May 5, 2014  
BCE File.: 13136

**Re: Revisions to 120 Veranda Street Subdivision Plans**

Enclosed please find the revised plans and stormwater report for the property at 120 Veranda Street in Portland. At your request, we made the following changes since the last submission on April 1, 2013:

C-300

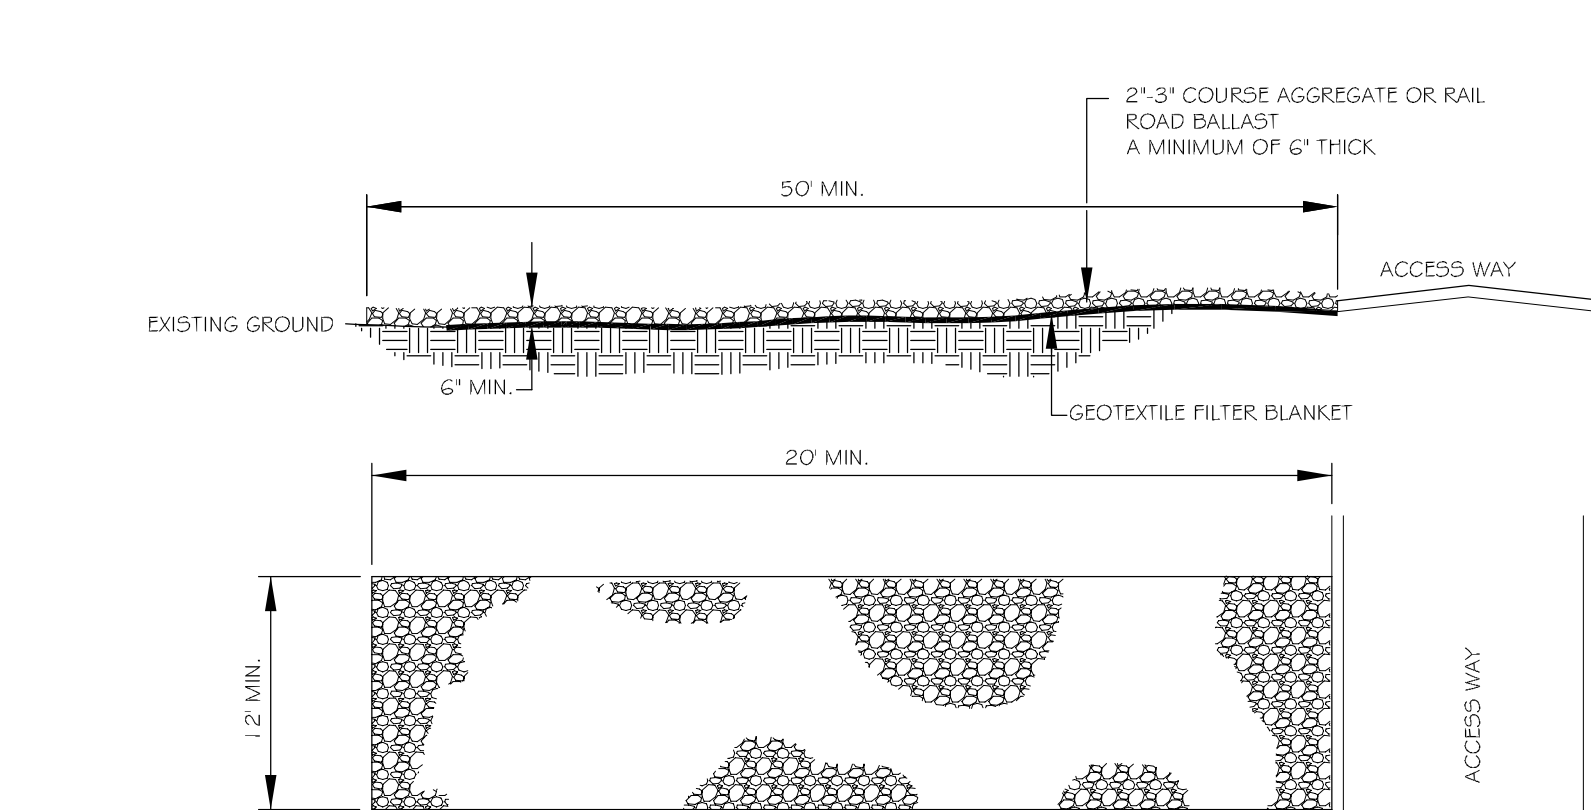
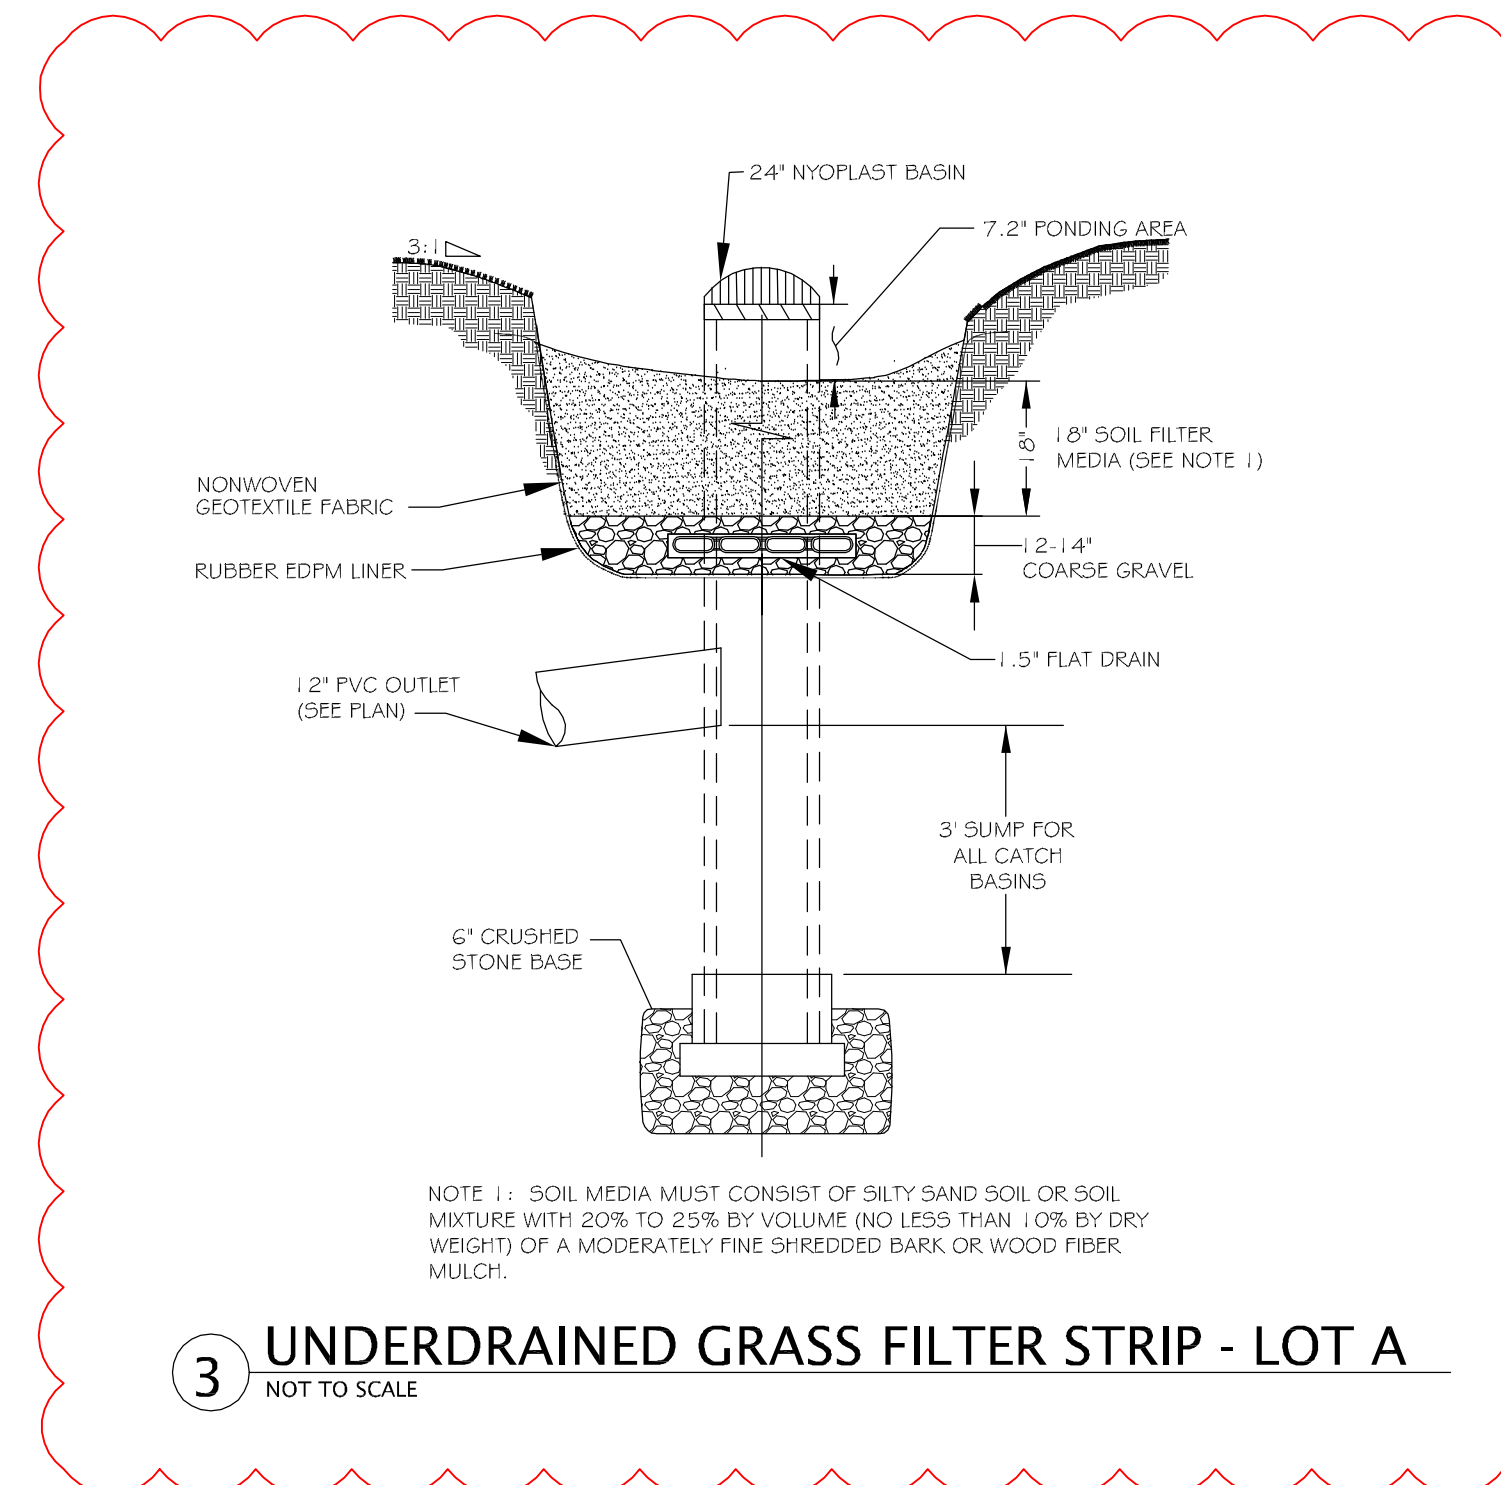
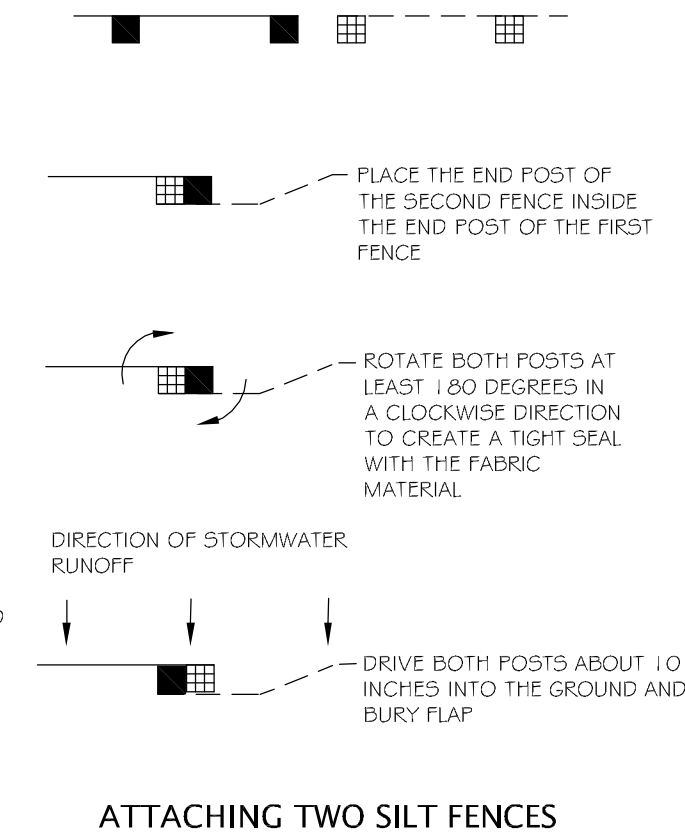
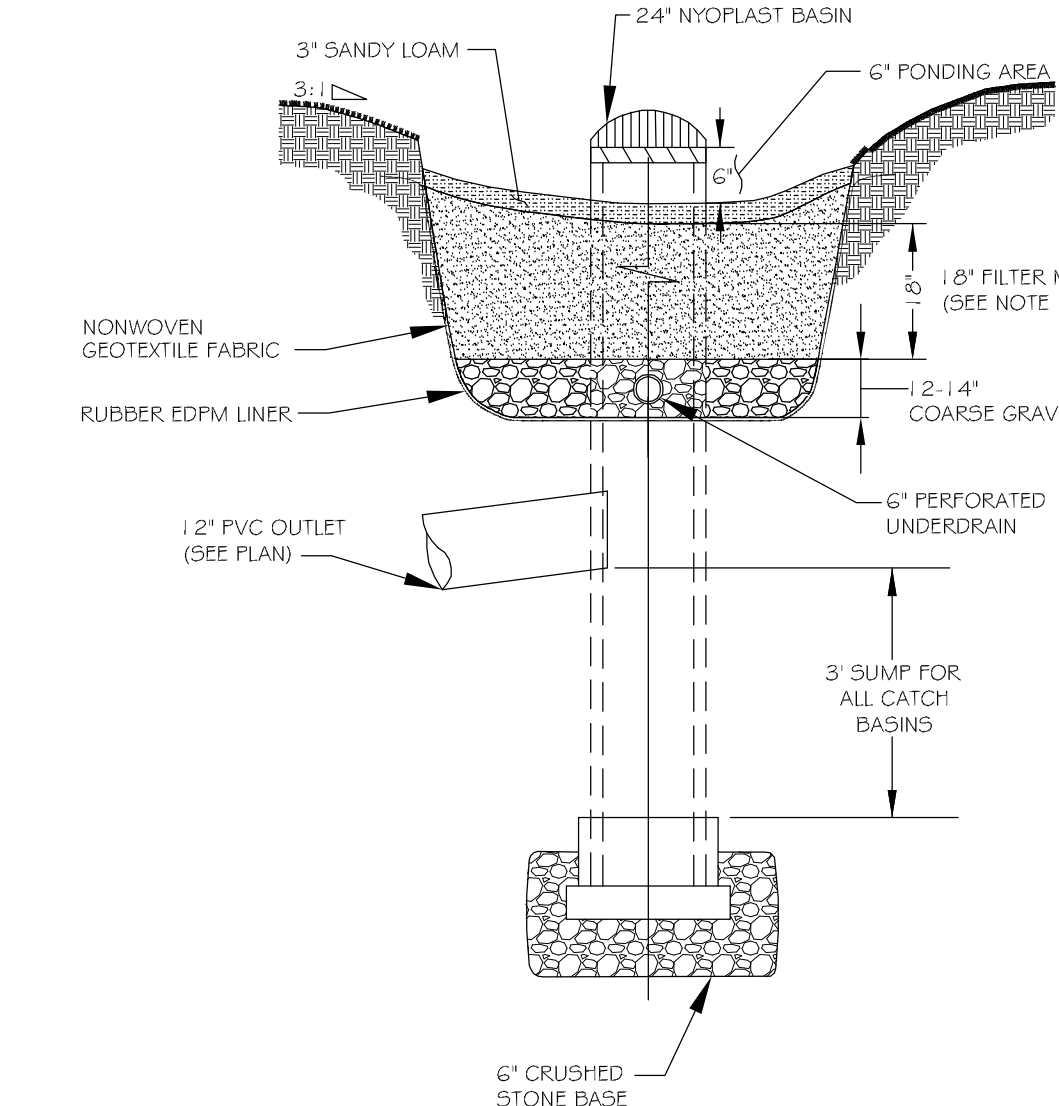
- Reduced the Lot A proposed building footprint by 168 sf,
- Shifted the building on Lot A by 4 feet towards the northeasterly property line,
- Added two 9'x18' parking spaces for a total of four spaces.
- Adjusted DMH 2 for the elevation of the drain pipe stub to DMH 1, which was installed slightly higher to avoid other utility conflicts in the ROW,
- Moved the proposed underdrained grassed soil filter from the back of the house to the front
- Updated Sheets C-100, C-300, D-100 and the Stormwater Report.
